# City of Ryde Submission

**For Modification 5 of SSD-5093  
6 Halifax Street, Macquarie Park  
(Lot 117, DP 1224238)**

**Submission Date: 31 August 2022**

Figure1. Proposed changes regarding land zoning in Housekeeping Review Planning Proposal 2022

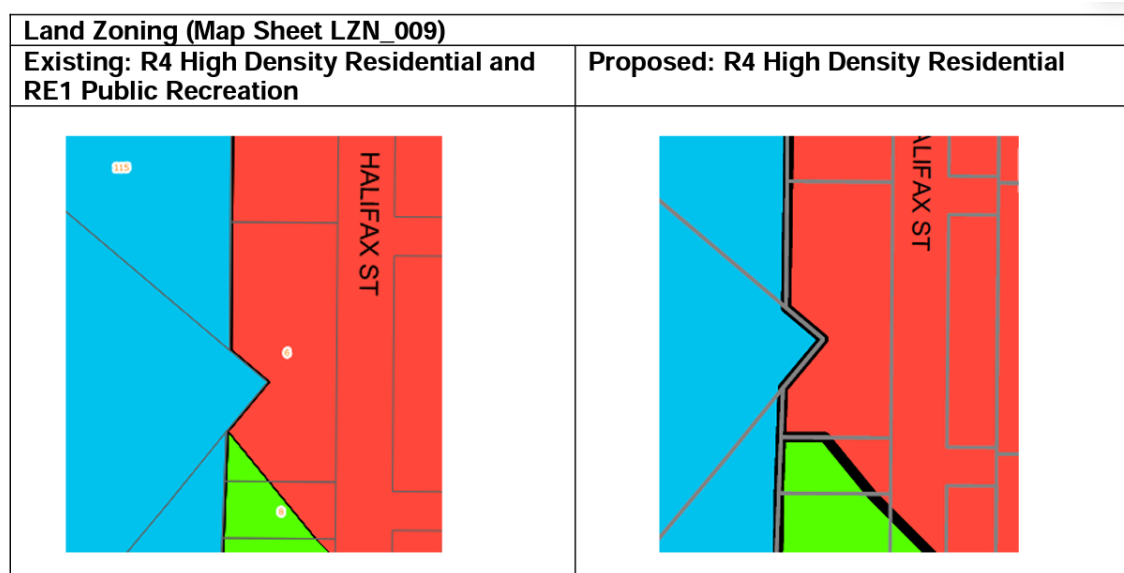
The Planning Proposal includes the rezoning of a small portion of land zoned 'RE1 Public Recreation' to 'R4 Low Density Residential' on the subject site to correct a zoning anomaly. It also seeks to apply a floor space ratio (FSR) of 3:1 and maximum height of 75 meters across the whole site to be consistent with the remainder of the site (refer to Figures 1, 2 & 3 below).

Figure2. Proposed changes regarding floor space ratio in Housekeeping Review Planning Proposal 2022

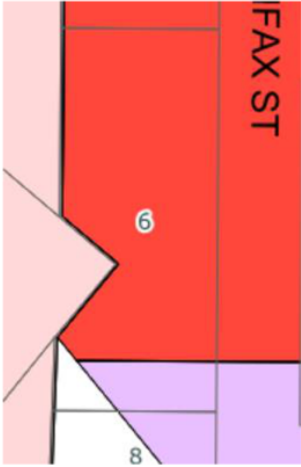
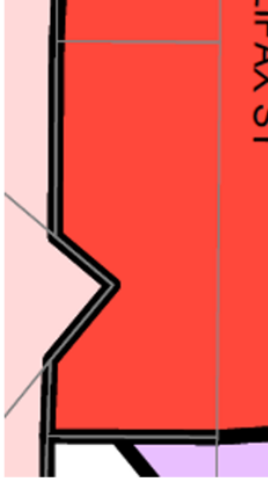
The assumptions used for FSR calculation in Table 2 of the submitted Statement of Environmental Effects (SEE) are inconsistent with the above exhibited Planning Proposal. Based on the FSR sought by the Planning Proposal, the site will only achieve a base GFA of 7,521m<sup>2</sup>, or a maximum GFA of 9,025m<sup>2</sup> should a bonus of 20% is applied under the *State Environmental Planning Policy (Housing) 2021* (Housing SEPP).

Figure 4. Subject site's relative location to the Wicks Road South (Garungul) neighbourhood

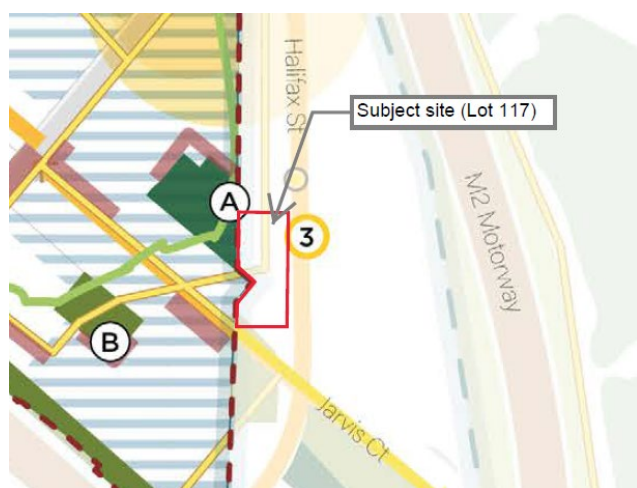
The proposed modification should take into consideration the increased overshadowing impact on the proposed future 'Corridor Square' (labelled 'A' in Figure 4) located immediately to the west of the site and also its implications on a fine-grained pathway (represented by a yellow line in Figure 4) appeared running through the northern portion of the site.
